MP08_0238 (MOD 17)

1 DENISON STREET, NORTH SYDNEY

The modification relates to alterations to the basement levels including reconfiguration of car and motorcycle parking and the Little Spring Street elevation.

LITTLE SPRING STREET- WEST ELEVATION A

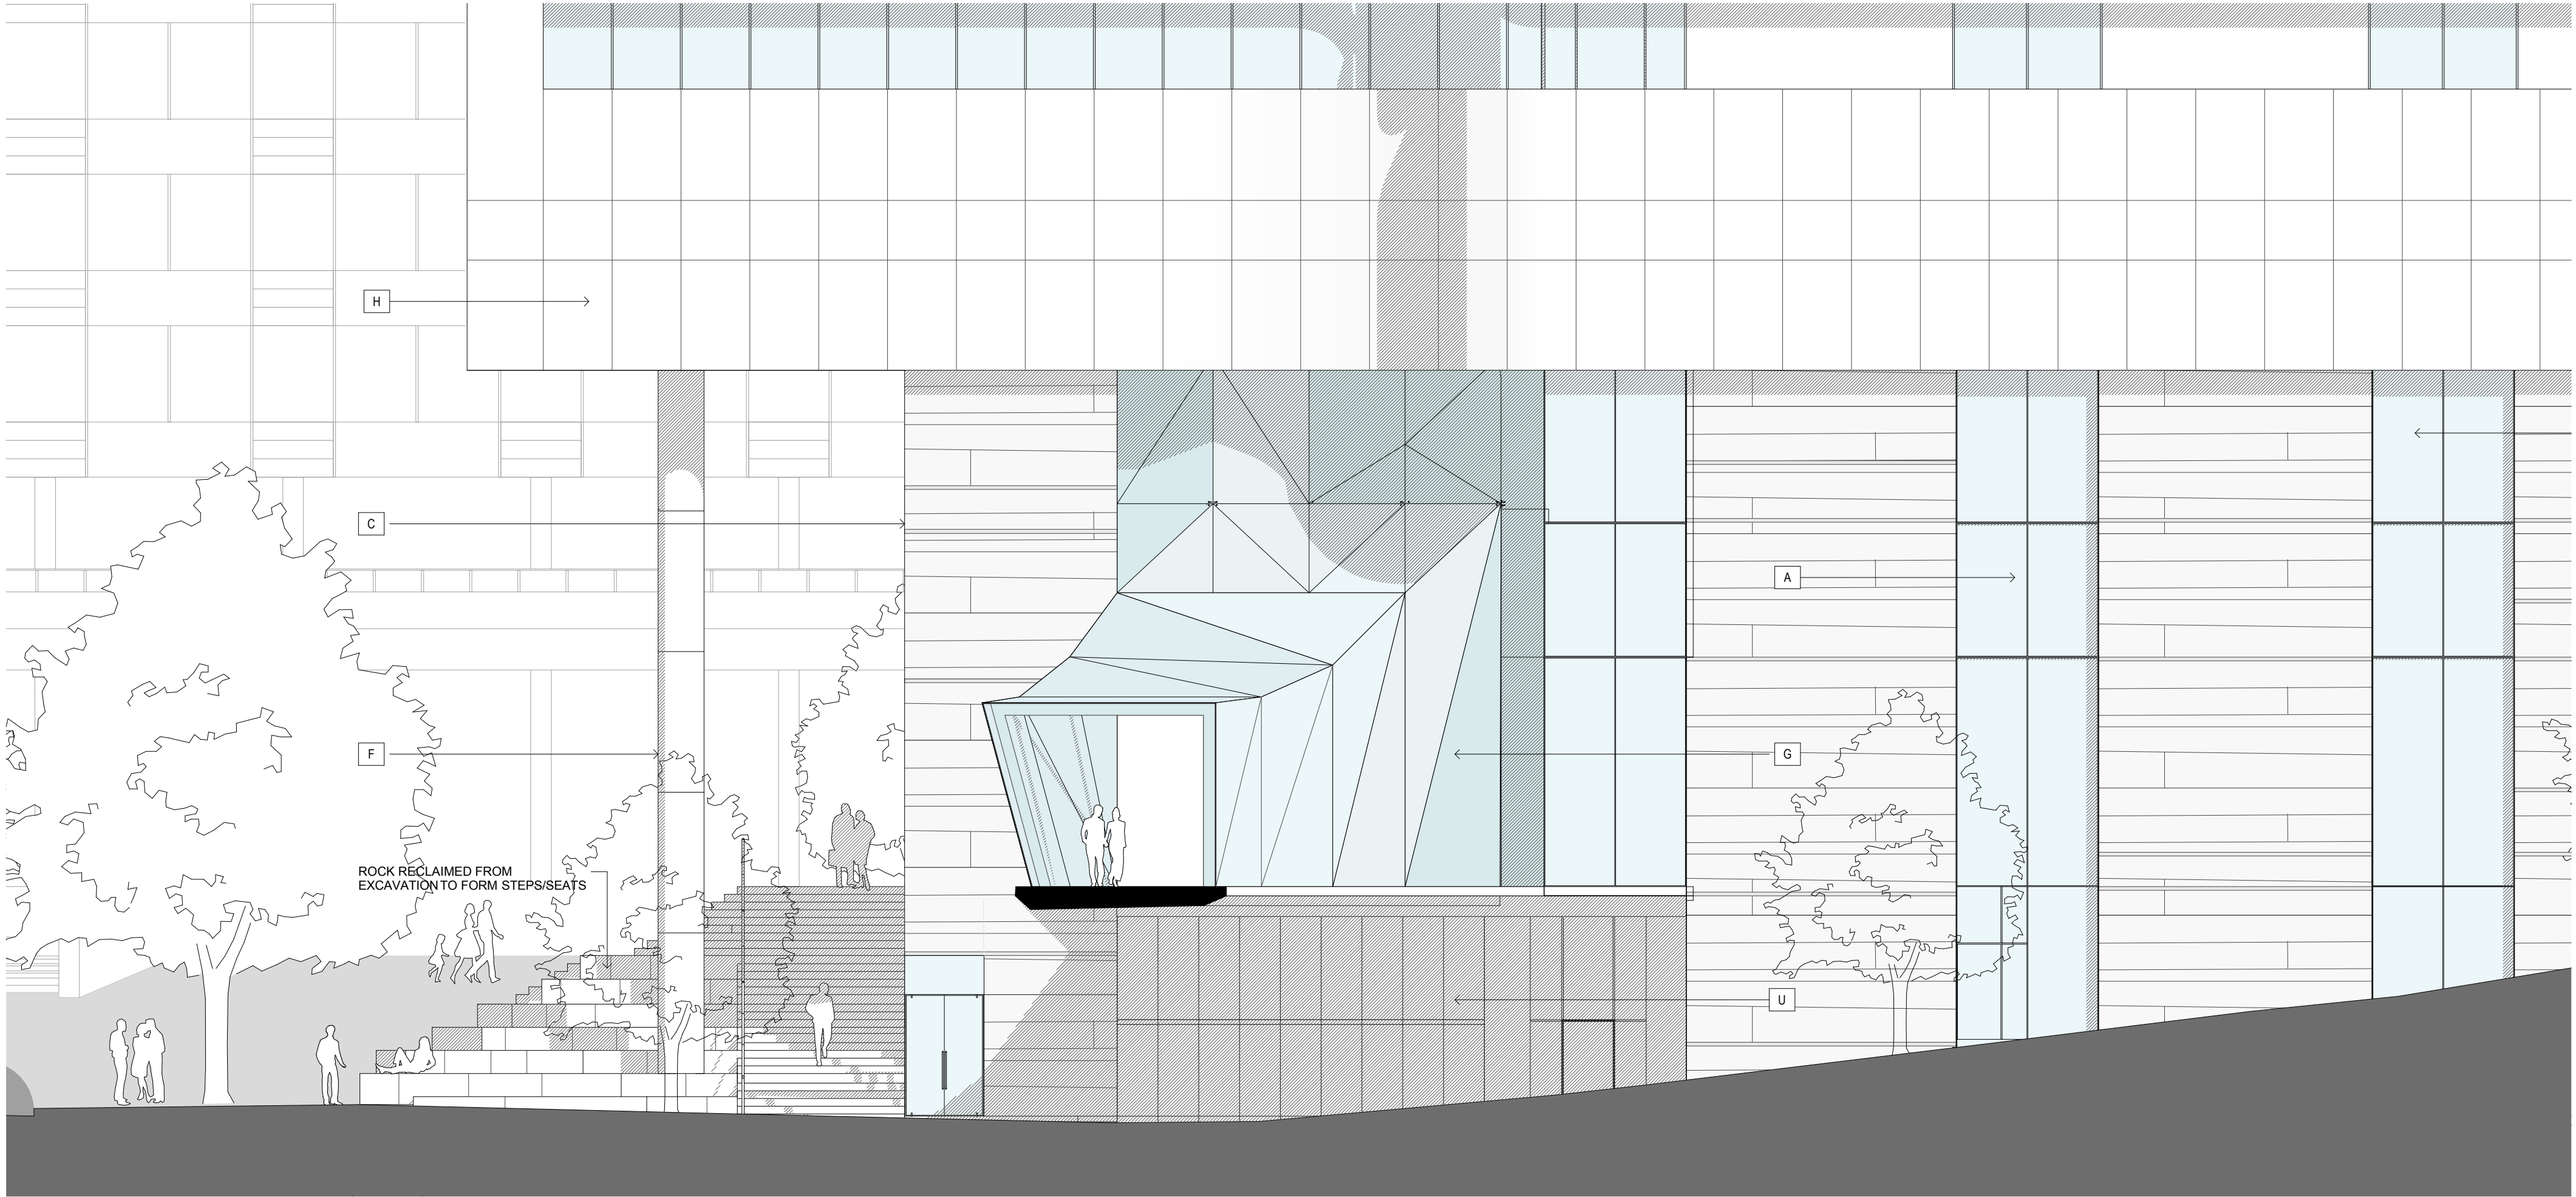
Council is not concerned with the change in materials and finishes of the Little Spring Street elevation to reduce the amount of louvres in this location and increase the stone cladding provided there is no encroachment of the street alignment/boundary. Then minor changes in the layout of parking on the other basement levels are also not a concern.
